# Charlotte Department of Transportation

## Memorandum

**Subject:** Rezoning Petition 08-158: Located on the northwest corner of South Mint Street and West Park Avenue (*revision received 4/22/09*)

CITY OF CHARLOTTE, MECKLENBURG COUNTY, NORTH CAROLINA
FOR
CONDITIONAL ZONING PLAN
FOR
GREATER GALILEE BAPTIST CHURCH
501 W. PARK AVENUE
AMENDED PETITION #2008-158

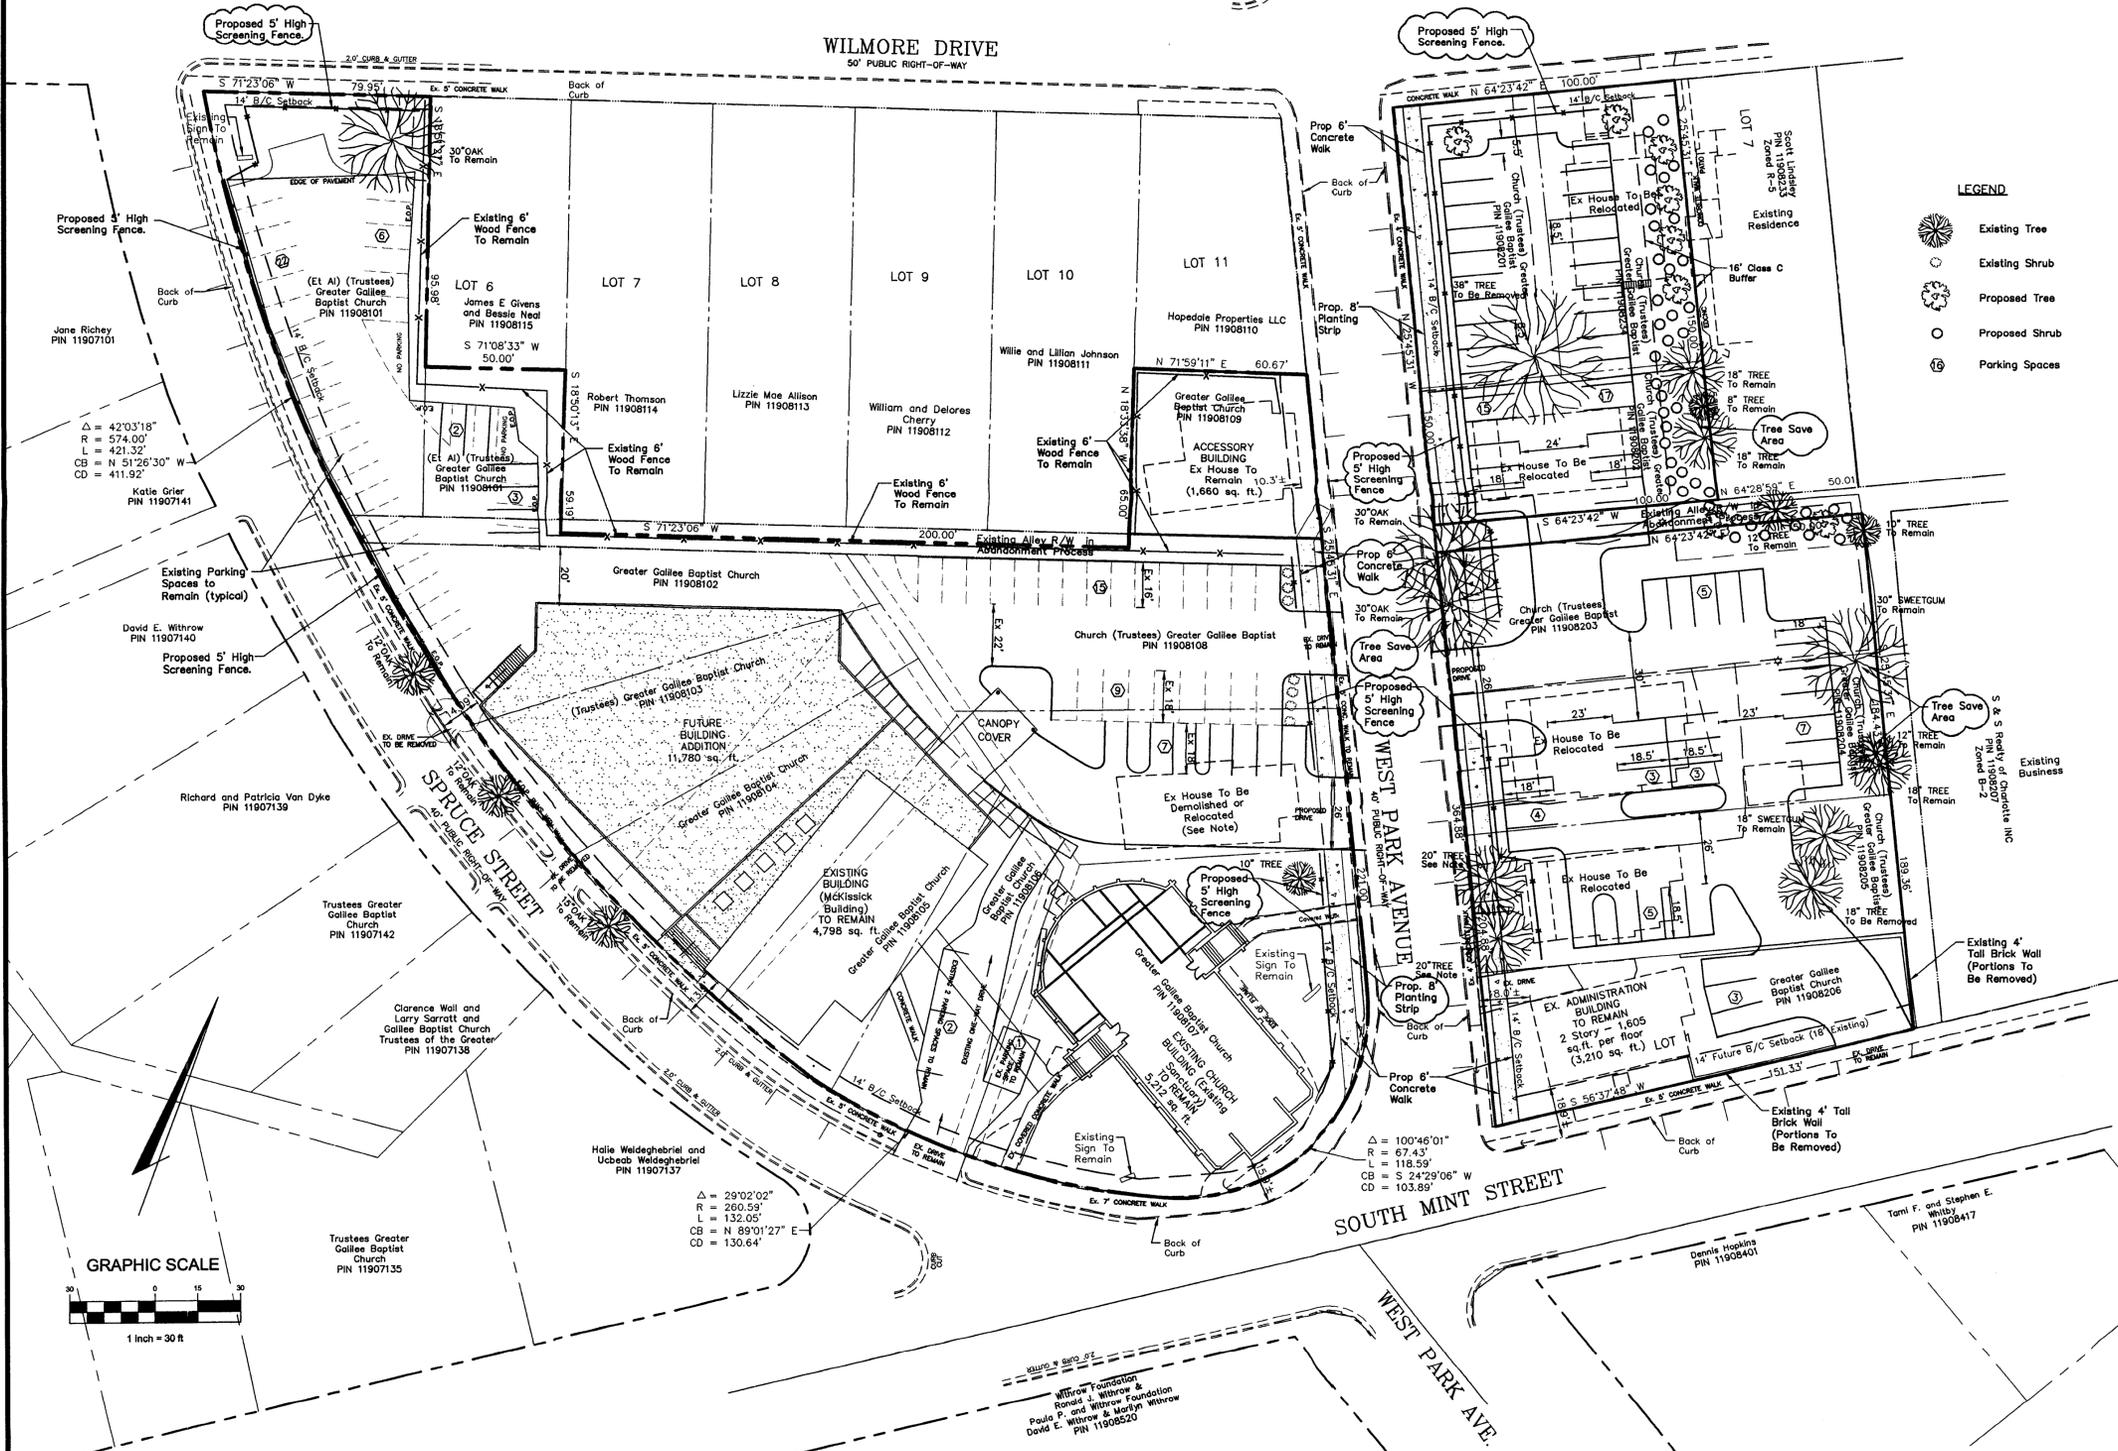
1. Parking calculations need to be included on the site plan to ensure sufficient parking is available. These parking spaces need to be shown on the site plan and cannot be located in the setback. (*Previous review comment*)
2. In the Transit Oriented Development (TOD) the setback is measured from the back of either the existing or proposed curb line. Mint Street is classified as a street needing a "New Cross-Section". The proposed curb line will be located approximately 4 feet behind the existing curb line to provide an ultimate back-of-curb to back-of-curb width of 49 feet (currently 41 feet). The building setback is measured 16 feet from the back of this future curb. The future location of the curb should be shown on the site plan so any future buildings on this site will adhere to the ultimate curb location.
